# Tween Bridge Solar Farm

## 9.9 Statement of Common Ground with Natural England

**Document Reference: 9.9**

**Revision 1**

Figure 1: Non Breeding Bird Mitigation Plan

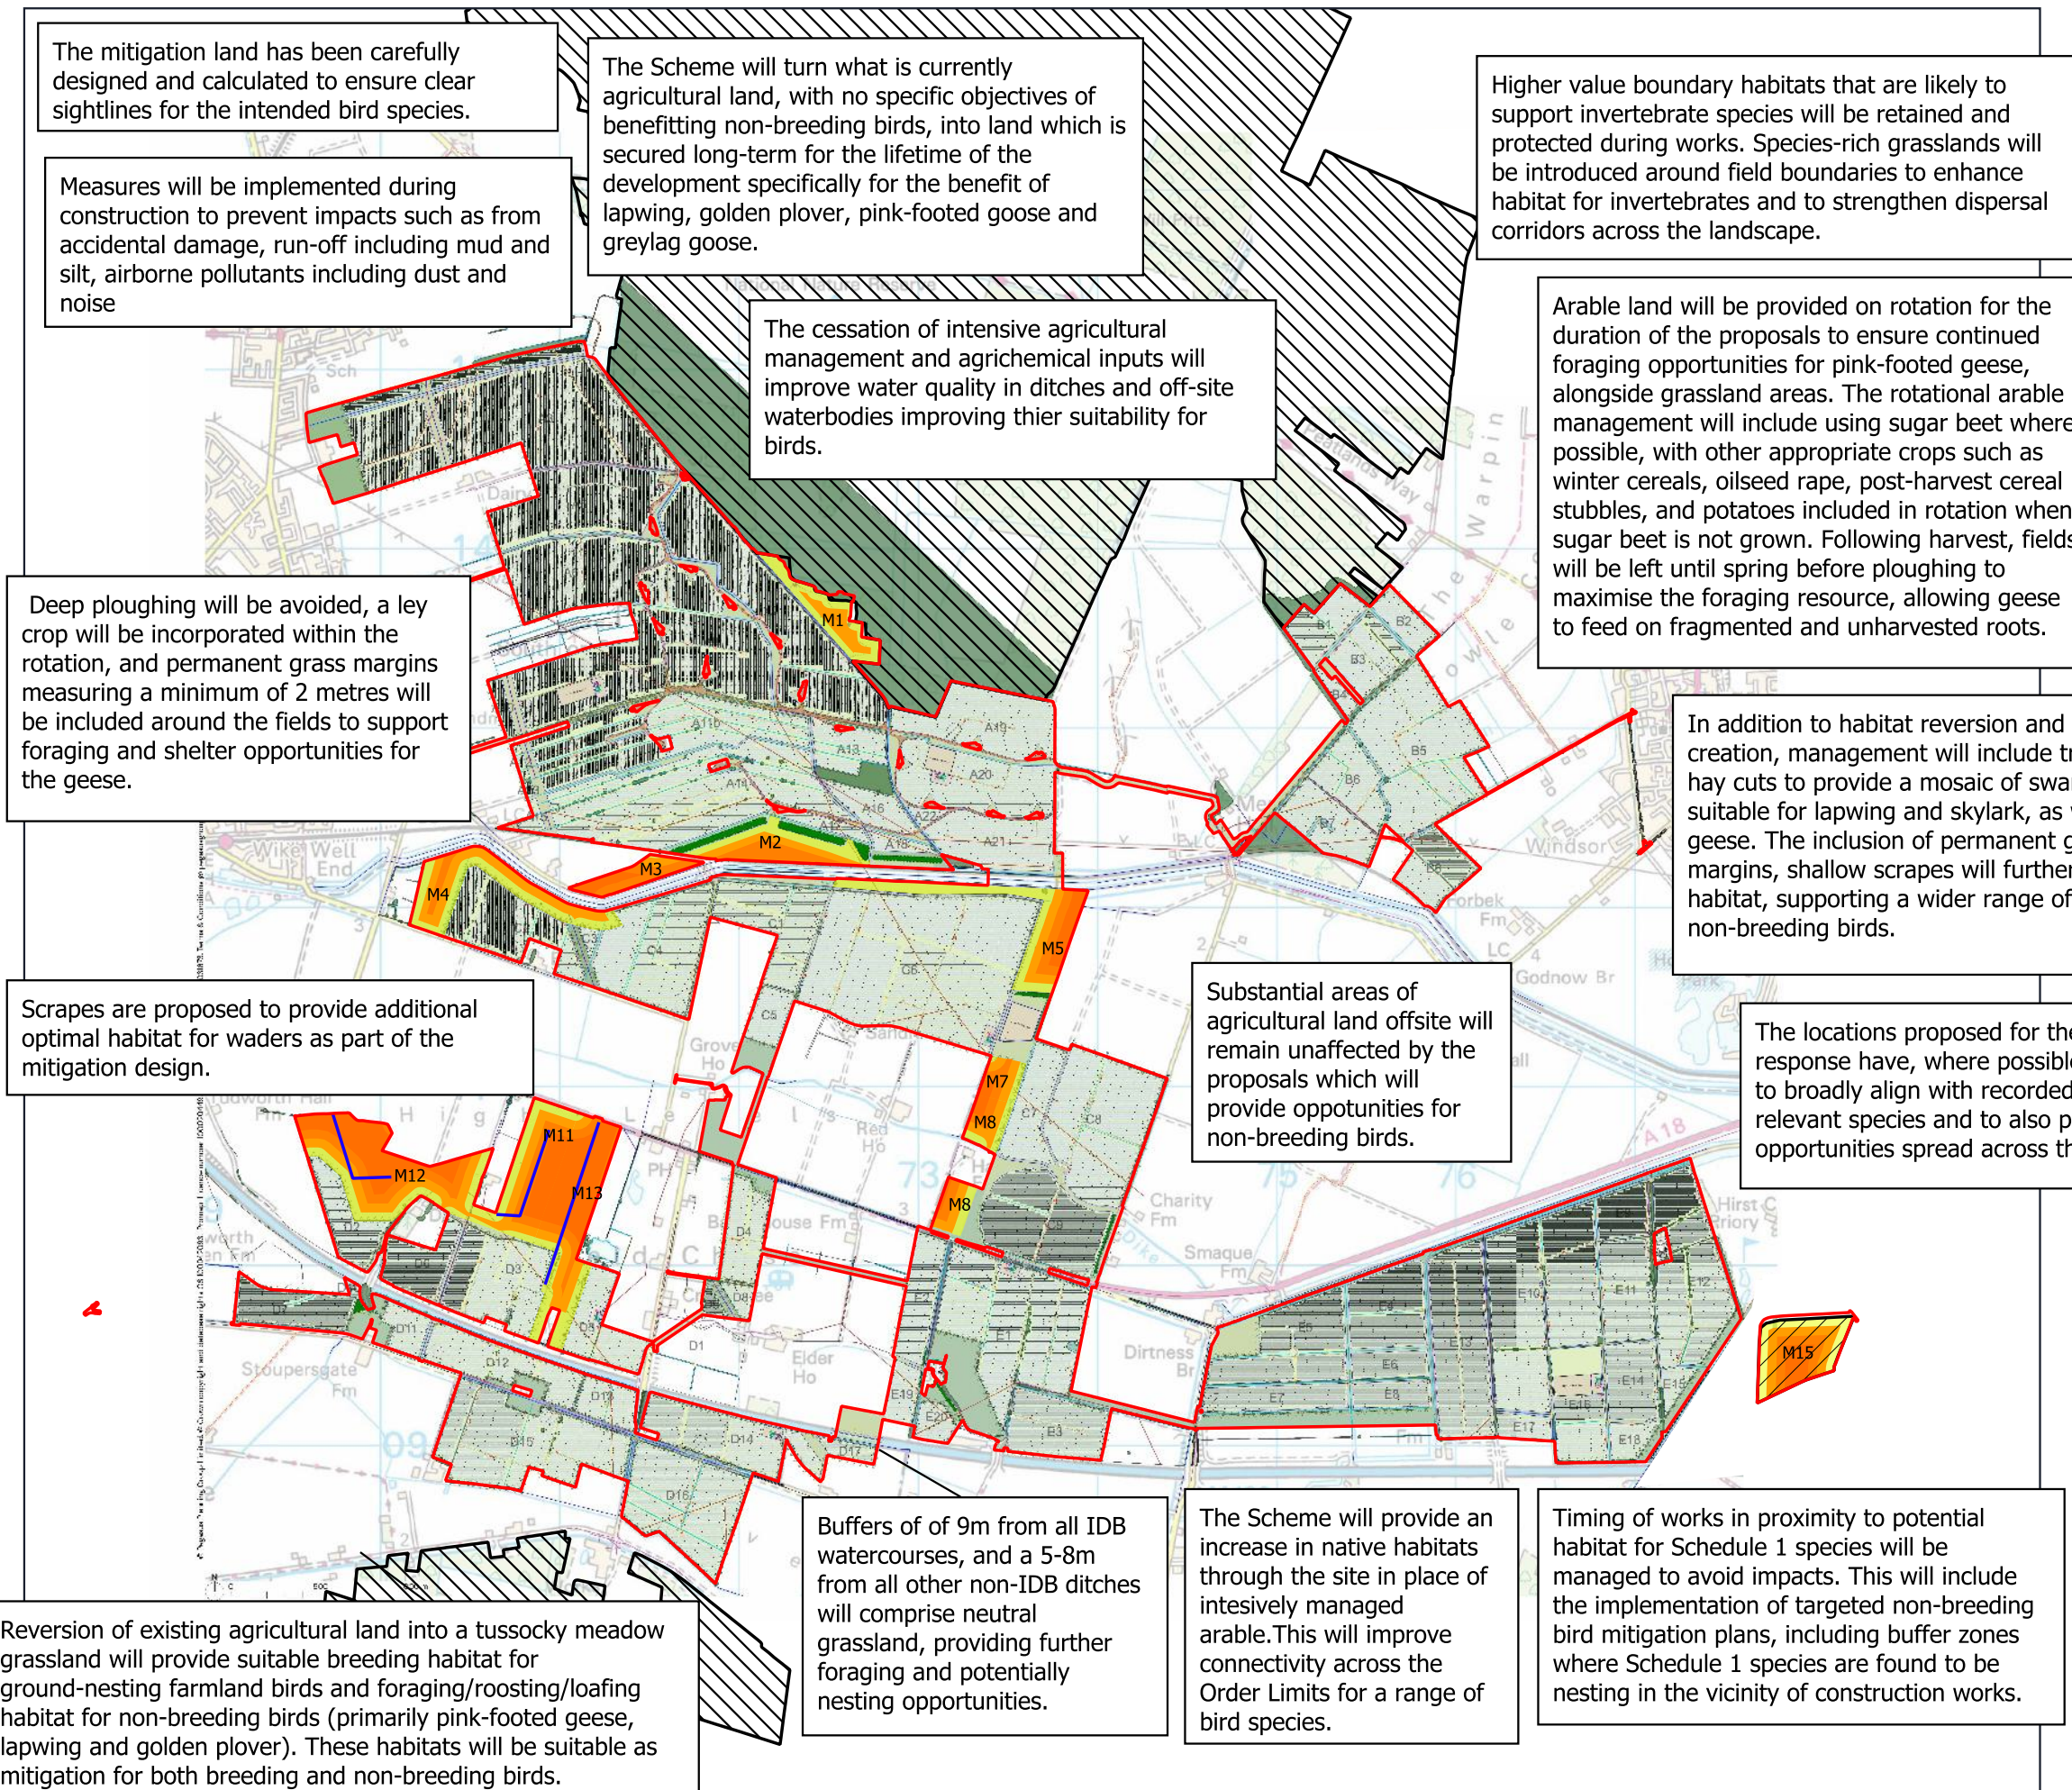
<p>of the carrying capacity of different habitat types.</p> <p>For information, we highlight that golden plover and lapwing rely on open vistas to forage, and the relevant mitigation areas should seek to deliver this site characteristic to ensure suitability for these species. Golden plover tend not to use fields less than 10ha, and fields 15–30ha or larger are used more often especially when in flocks of over 100 birds<sup>2</sup>.</p> <p>We advise that existing habitat suitability should be factored into the assessment of the proposed mitigation areas. We recommend that the design of mitigation areas should take into account potential benefits of securing areas of higher existing bird usage as mitigation areas through enhancement, rather than the establishment of entirely new habitats which have a lower usage baseline. For example, the <i>Wintering Bird Survey Results – 2023 to 2024 (Lapwing)</i> show significant lapwing usage of the southernmost point of the site in both years of surveys.</p>	<p>The Applicant confirms that Bird Days calculations have been used as a tool to inform the approximate mitigation area required, alongside ecological knowledge of the carrying capacity of different habitat types. Further detail is provided within the <b>Report to Inform Habitat Regulations Assessment [Document Reference 5.3 Revision 3]</b>.</p> <p>Surveys undertaken demonstrate that golden plover are not a functionally linked species and therefore no species-specific mitigation is required. However, the mitigation areas have been designed to provide open vistas suitable for lapwing, which will also provide suitable habitat for golden plover.</p> <p>Section 2 of the Non-Breeding Bird Mitigation Strategy submitted as <b>Environmental Statement Appendix 7.10 Non-Breeding Bird Mitigation Strategy [Document Reference 6.3.7.10 Revision 2]</b> sets out calculations of land availability with 150 m open vistas, with this information also included within the <b>Report to Inform Habitat</b></p>

<p><b>Regulations Assessment [Document Reference 5.3 Revision 3]</b> and provided as part of Figure 1 within this document.</p> <p>Several mitigation parcels larger than 10ha with at least 150 m open vistas are provided, including M12 and M13.</p> <p>A total of 43.67ha of mitigation land with 150 m open vistas is located beyond 600 m of wind turbines, in line with point NE3 (see below), and is available for lapwing. Bird Days calculations demonstrate that 24.99 ha is required for lapwing (Appendix 2 of the <b>Report to Inform Habitat Regulations Assessment [Document Reference 5.3 Revision 3]</b>) confirming that more mitigation land is provided than required. Additional mitigation land within 600 m of turbines, including parcels M1 and M2, is also available, and lapwing have been recorded using these areas, therefore ensuring that additional land is available for this species.</p> <p>When considering mitigation land beyond 600 m of turbines, 108.84ha remains available for pink-footed</p>
